Response to Planning application from Hertfordshire County Council (T and CP GDP Order 2015)

District ref: 6/2017/1319/VAR

The Spinney

Variation of condition 1 (approved plans) on planning permission 6/2016/1118/FULL dated 13/10/2016

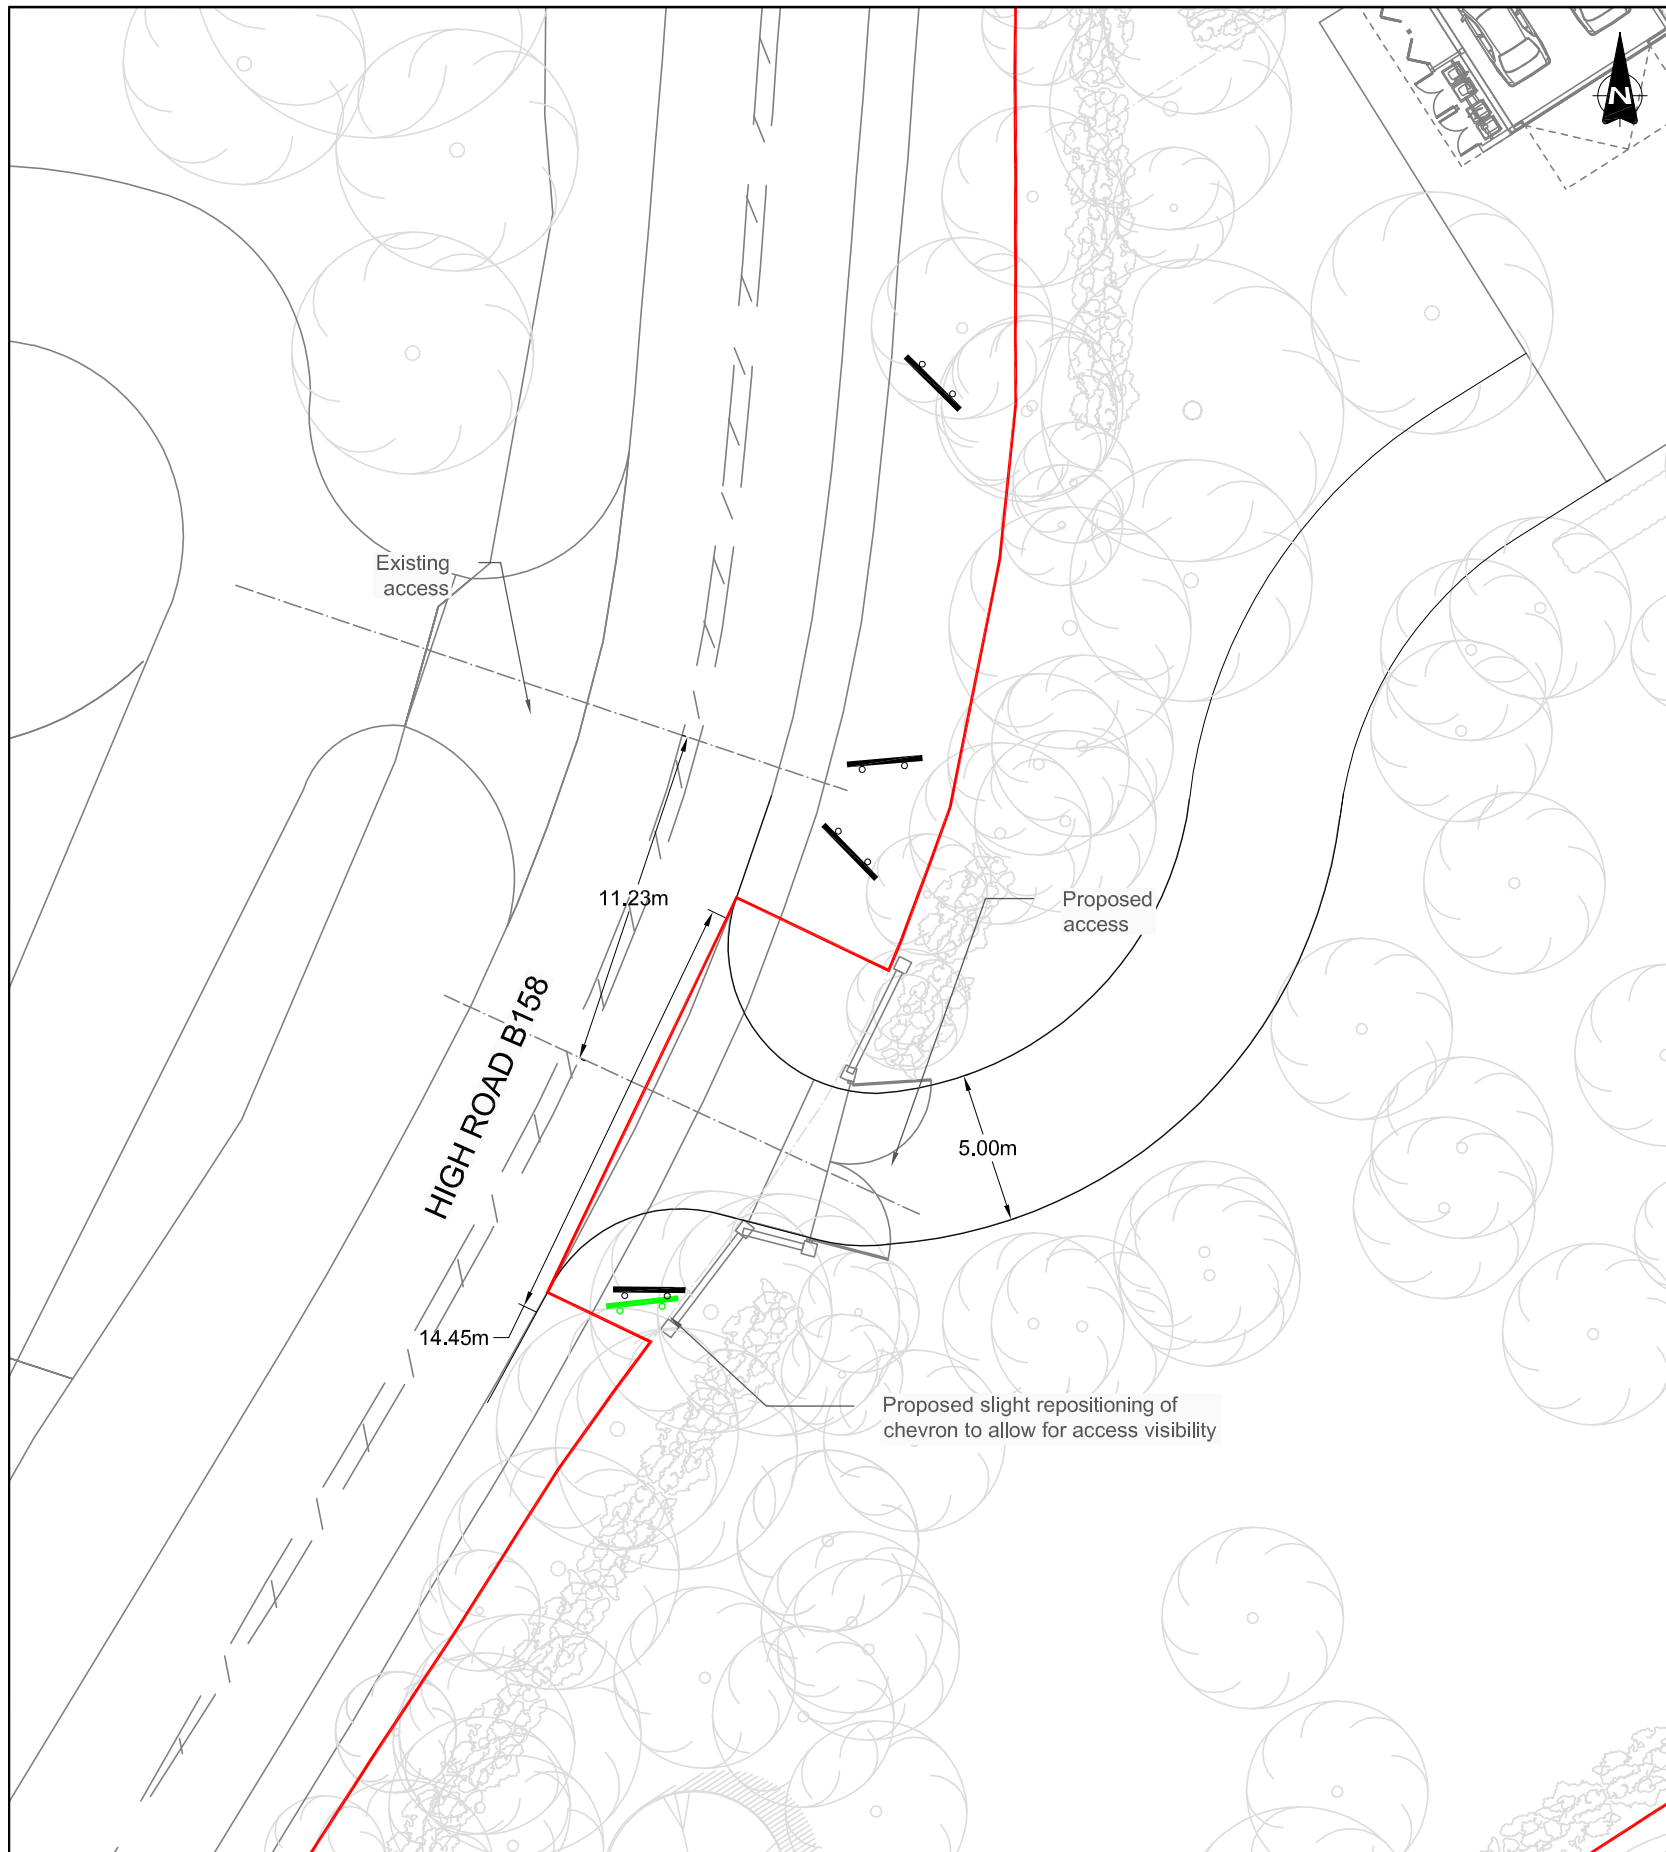
Situated on the B156 60mph secondary distributor road, where no accidents have been recorded in the previous five years according to our records. The relocation of the access remains acceptable in highway terms.

the gates are of a distance of a minimum of 6 meters from the highway edge, allowing a private car to pull off the highway reducing any conflict whilst entering the property.

Widths and dimensions remain acceptable.
